**RE: RESPONSE TO EIS - INTERNATIONAL CHINESE SCHOOL (SSD-10260) (WILLOUGHBY CITY)**

I refer to your email dated 27 September 2019 regarding abovementioned state significant development application. The proposed development seeks change of use for 211 Pacific Highway (the Site) from an office premises to a school and associated works, including:

01 Furniture layout - Ground Floor Plan  
1:100

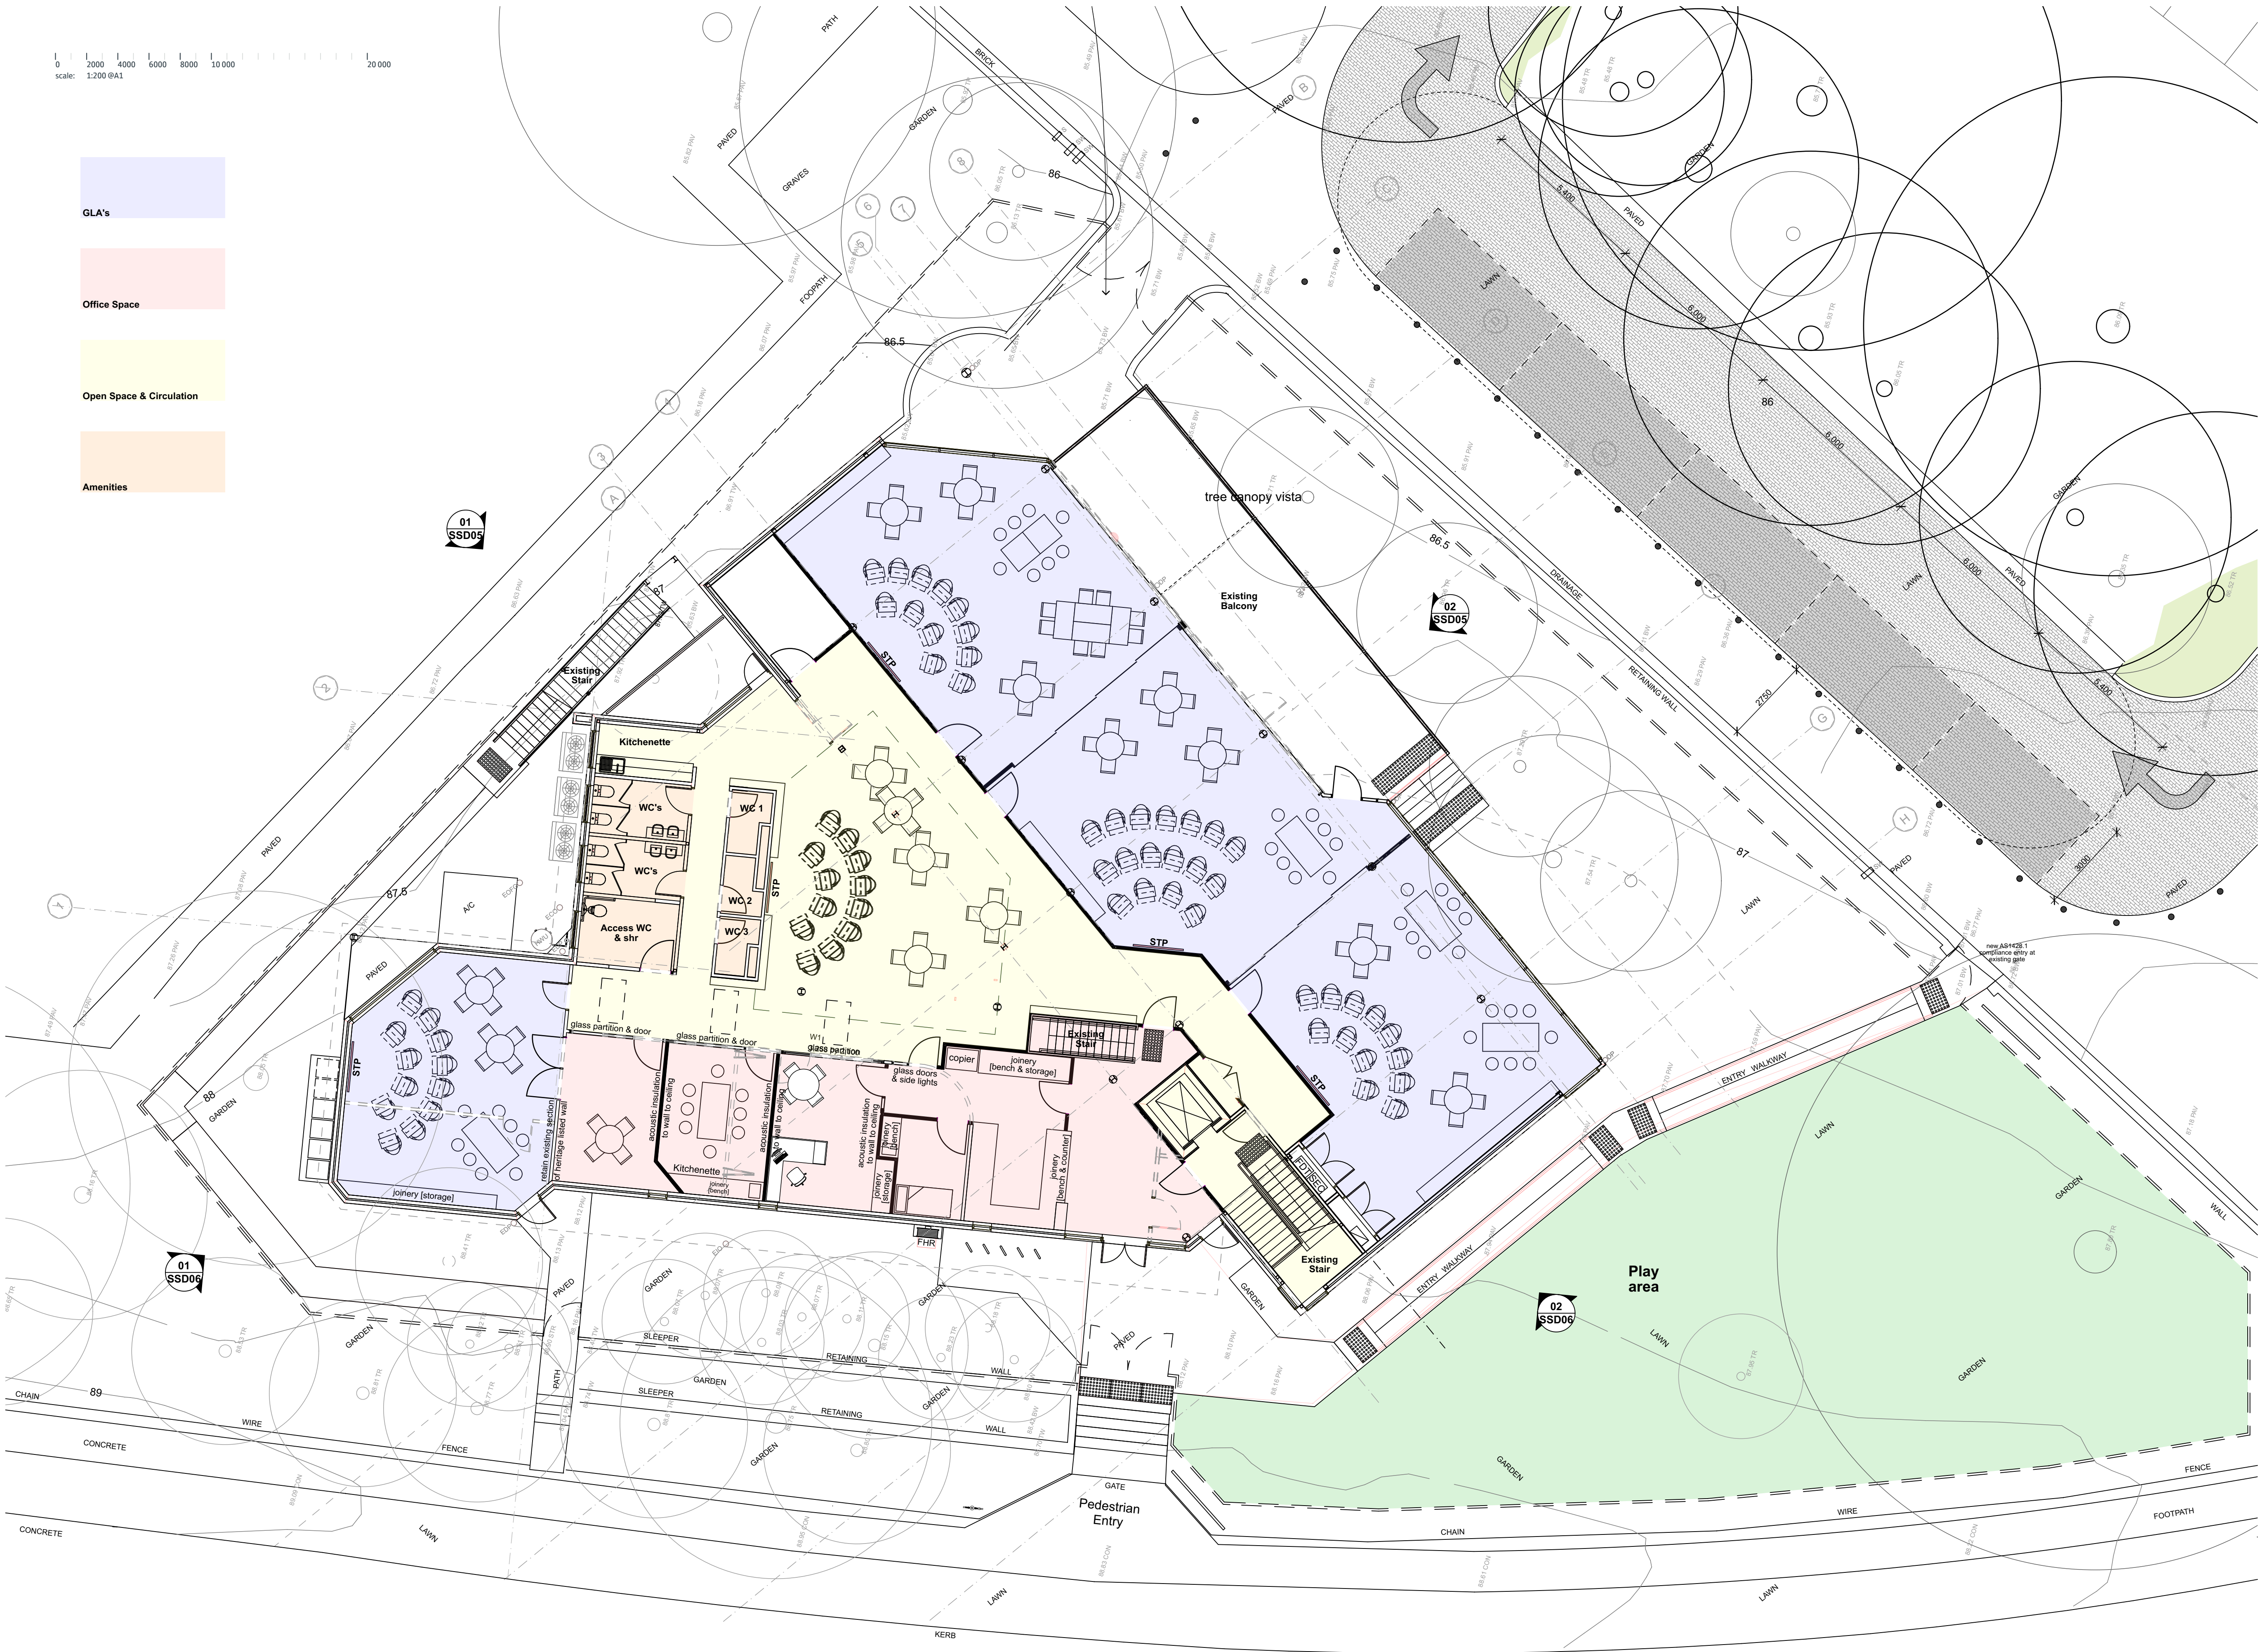
The central avenue, historically known as The Carriageway, which runs from Westbourne Street in the north to the Pacific Highway in the south provides a distinctive character to the Gore Hill Cemetery. Proposed works that include 'kiss and drop' area within The Avenue/ Carriageway, which will be demarcated by the removable bollards and new ground finishing, will have an unacceptable impact on both the physical and visual character of the heritage item.

The new use will also require an installation of a new security fencing inset from the boundary of the subject site. It is noted that information provided in the architectural drawings and the landscape plans show discrepancy between the type of fencing proposed, however it is understood that the fencing will be 2.1m high. Whilst the dense vegetation along the Pacific Way will mitigate the visual impact from the extra fencing, the views to the heritage site from The Avenue, along The Avenue and the views out from the subject site will be adversely affected by the proposed fencing.

Based on the above, the proposed use of the subject site as the primary school is considered to have significant adverse impact on the State Heritage Listed values of the site and is therefore not supported on heritage grounds. If the development application is approved by the Department of Planning, Industry & Environment, a condition is recommended to relocate the proposed 'Kiss and Drop' facility from The Avenue to the lesser significant area to the north east towards the Council's carpark.
